PLANNING CONSULTATION RESPONSE

Application No	2026/0083
Proposal	Erection of general agricultural building
Address	Land to the south of Bents Farm, Sheffield Road, Crow Edge, Sheffield
Date of Consultation Reply	08/07/2026
Consultee	Katie Lawrence, Planning Ecologist

PLAN

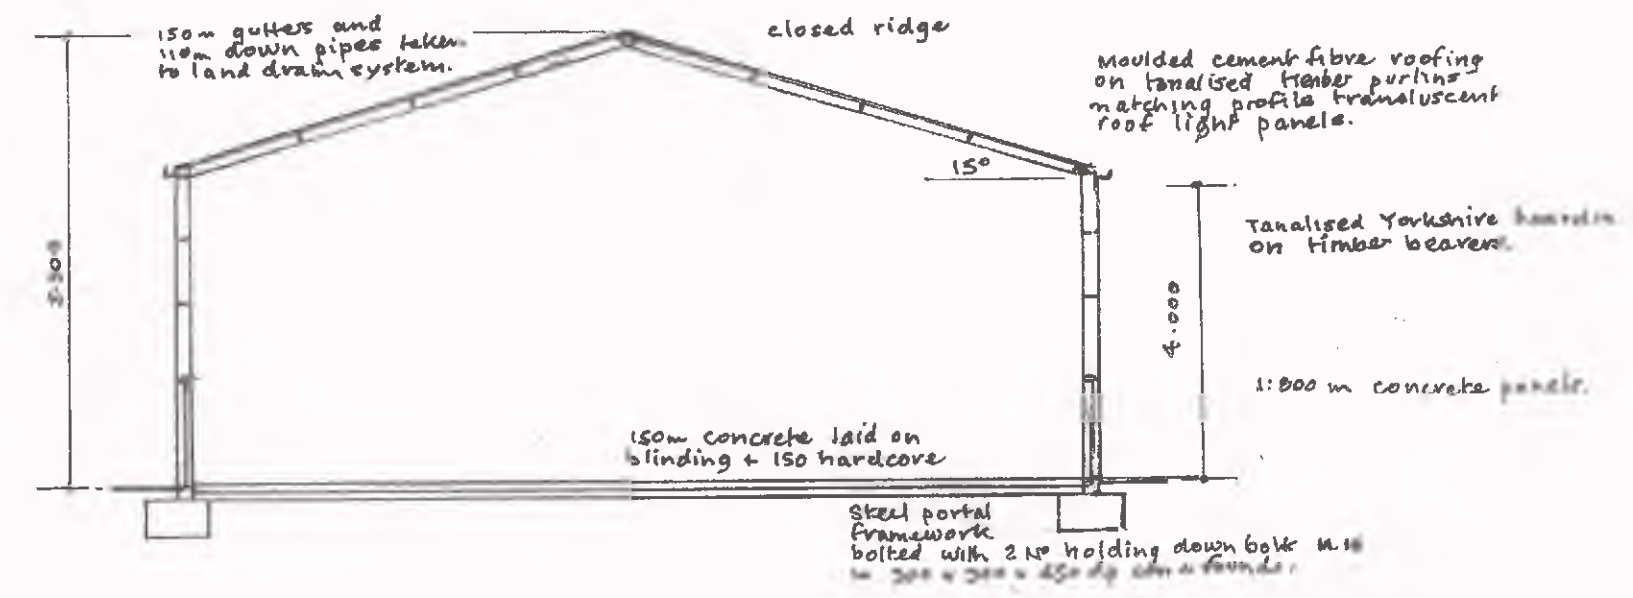
- The post-development plan and the metric account for the proposed agricultural barn. The proposals plan provided indicates an access route. Can the applicant confirm whether this will be surfaced and therefore if it should be accounted for within the metric calculation?

Figure 2. Post-development Habitats Maps

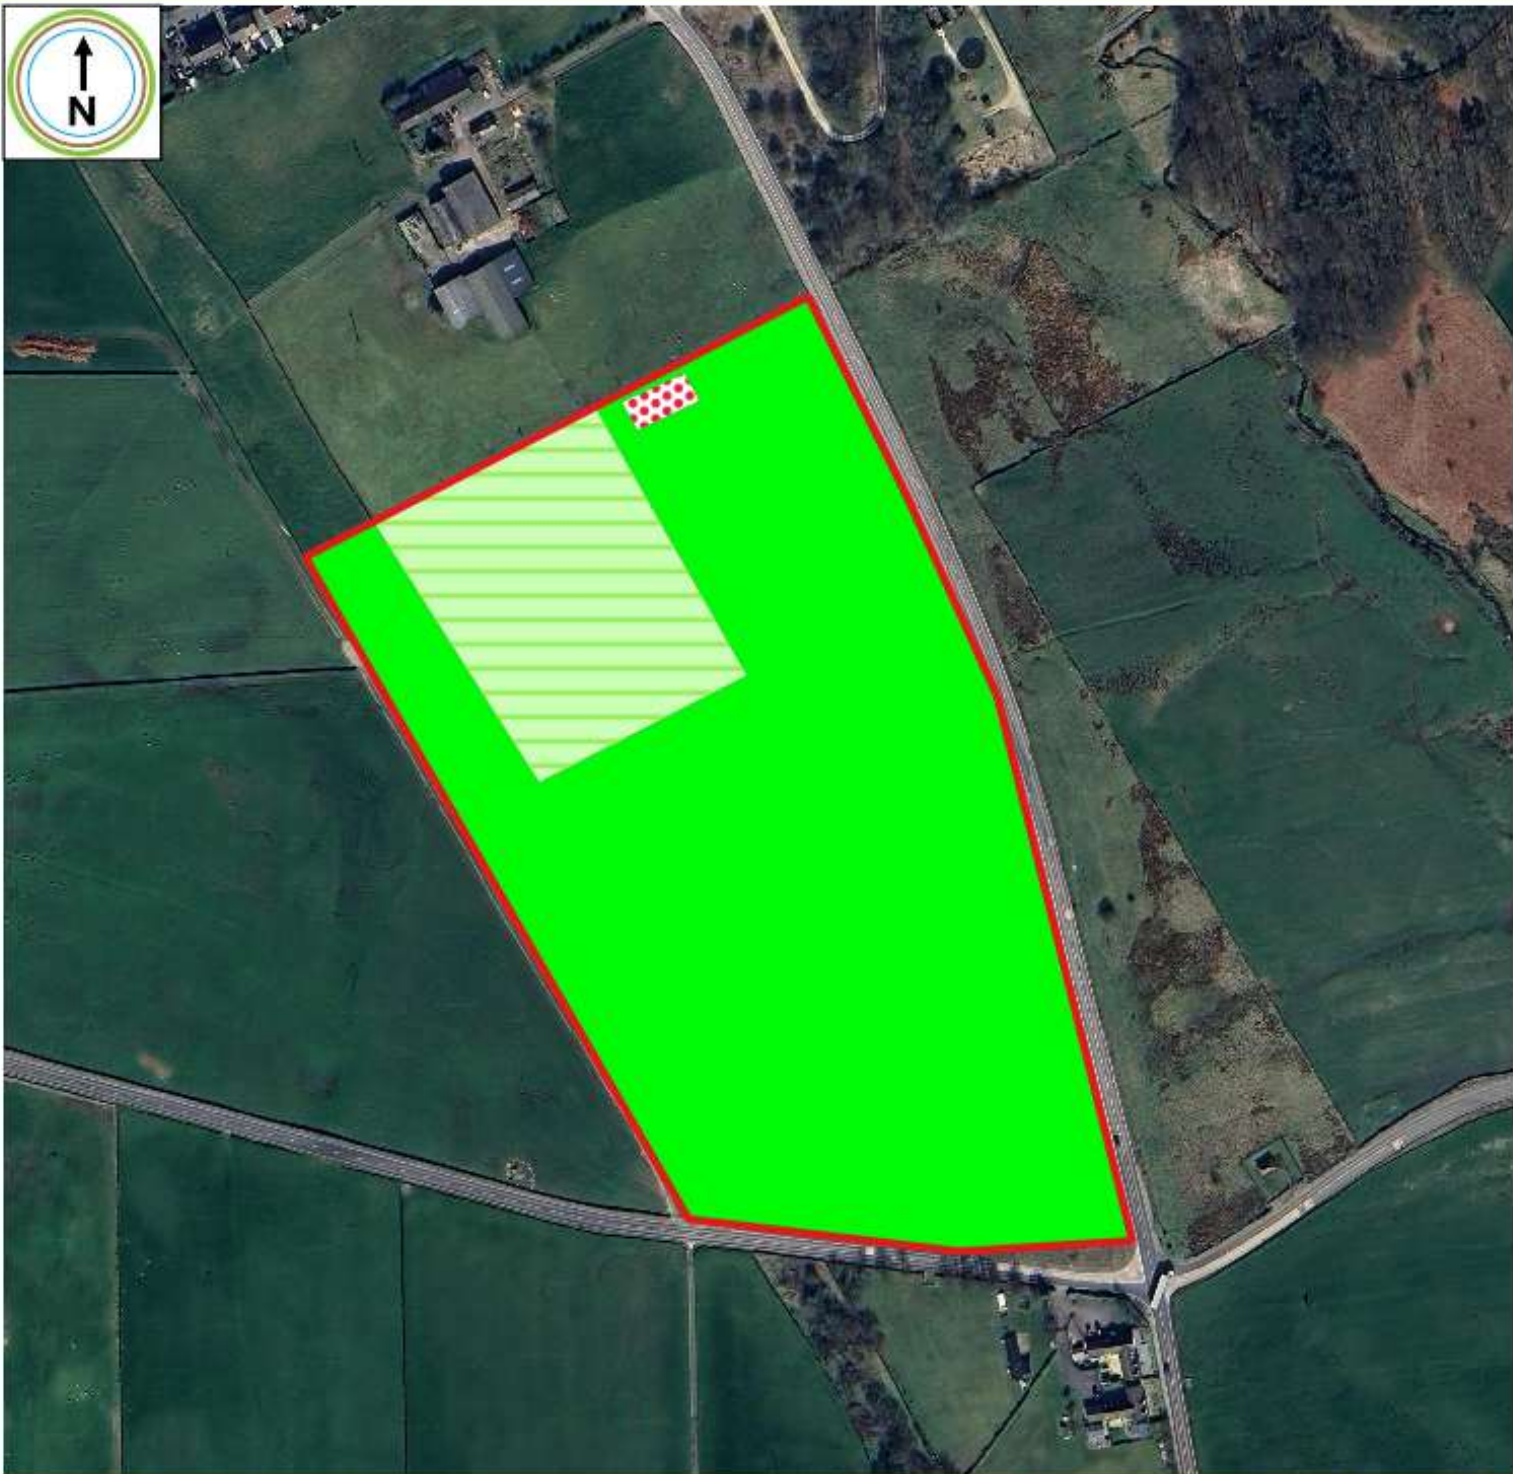
- The Biodiversity Net Gain (BNG) assessment and biodiversity metric submitted suggest that by enhancing a grassland field to the west of the proposed barn the 10% net gain can be achieved on site. Enhancement of a low distinctiveness grassland to a moderate condition and generating 3.93 habitat units is deemed to be significant on-site enhancement as set out in BMBC's biodiversity appendix (<https://www.barnsley.gov.uk/media/yyhmuadm/biodiversity-appendix.pdf>) with units delivered being equal to or greater than 0.5. On this basis, a Habitat Management and Monitoring Plan (HMMP) setting out the management and monitoring of post-development habitats over a 30-year period will be required. We would seek a monitoring fee for review of monitoring reports submitted over the 30-year period. Due to the small size of the proposed habitat enhancement areas, the LPA would seek a monitoring fee of £5000. The fee would be secured as part of a Section 106 agreement. The applicant should advise whether they are happy to proceed on this basis as this would need to be arranged prior to planning permission being granted.

- It is noted that the red line boundary covers a significantly greater area than the proposed barn and therefore takes into account habitats which aren't to be affected by the proposals but which they have to provide a 10% gain for. When inputting an area of 0.1ha of modified grassland within the metric (the development area may be less/greater), deducting the barn area and then inputting seven small moderate condition trees within the habitat creation tab this allows for a 13% net gain. As set out within our biodiversity appendix we would not look to secure a HMMP (and therefore a monitoring fee) where a small number of trees are proposed and would condition a five-year Biodiversity Enhancement Management Plan instead. The applicant may wish to consider this as an alternative.

- It is noted that the Biodiversity Net Gain assessment report states that the grassland will be enhanced to other neutral grassland, a grassland of medium distinctiveness, whilst the metric proposes to maintain the grassland as the low distinctiveness habitat modified grassland but enhance its condition. This should be checked and amended.
